From: 
To: [Sunnica Energy Farm](#)
Subject: Sunnica – EN010106 Unique Ref nos : AFP191
Date: 28 March 2023 16:10:07
Attachments: [image934915.png](#)
[image359091.png](#)
[image937340.png](#)
[image567563.png](#)
[image230229.png](#)
[image741650.png](#)
[image381994.png](#)
[image580753.png](#)
[Appendix 1.pdf](#)
[Appendix 2.pdf](#)
[Appendix 3.pdf](#)
[Appendix 4.pdf](#)
[Appendix 5.pdf](#)

Sunnica – EN010106
Unique Ref nos : AFP191

Since Deadline 10 we have received further documents from Natural England. I have attached the documents as appendices and comment as follows:

Sunnica Energy Farm Proposed Layout - (Predictive BMV Land Assessment)

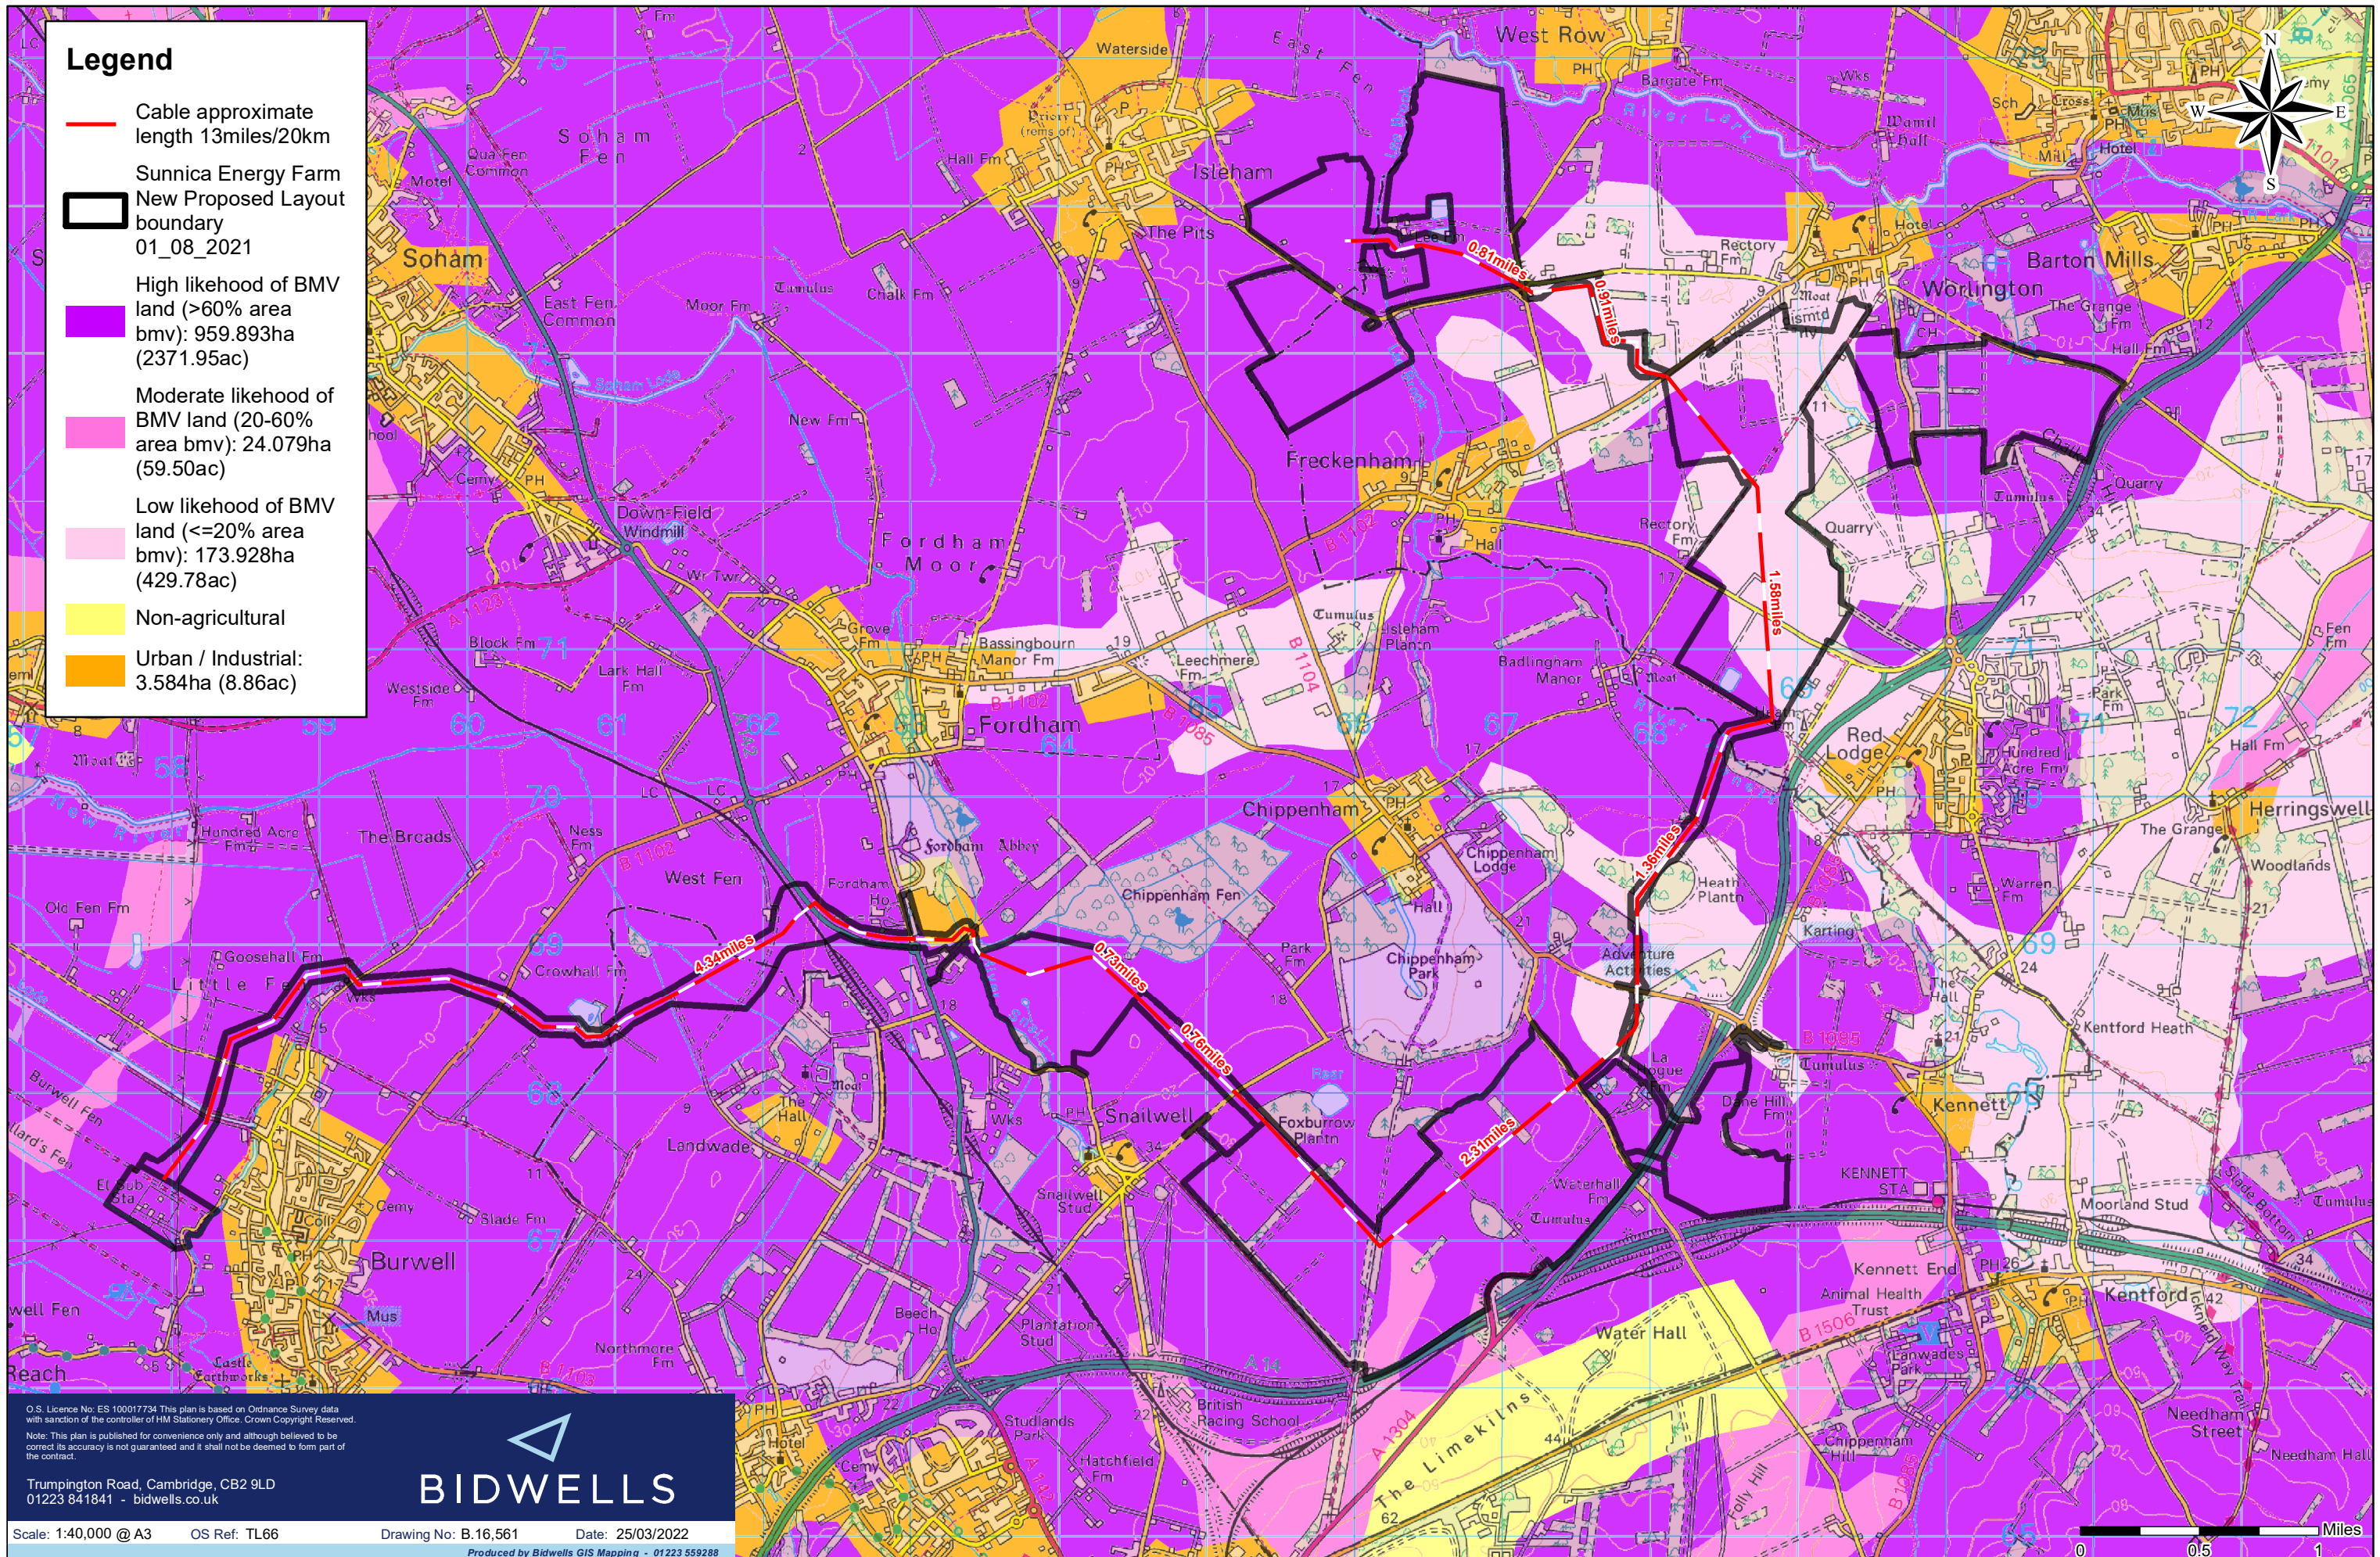
- 1/ Figure 12-2 does not reflect the survey results in [APP-115 Annexe F]
- 2/ No spreadsheet of moisture calculations is provided
- 3/ No evidence or justification is provided for the allowance used in the moisture calculations.
- 4/ The calculation of moisture balances is exact. NE'S calculations do not match DBSC's
- 5/ No explanation is given why the soil pits avoid the known areas of BMV and are dug in only 3 soil series when maps show there are 6 soil series
- 6/ No proof of a spade or a pick being used is given.
- 7/ No explanation is given to NE why when their predictive map shows 82% of the Sunnica site is 60% or more likely to be BMV and DBSC can only find less than 4%.
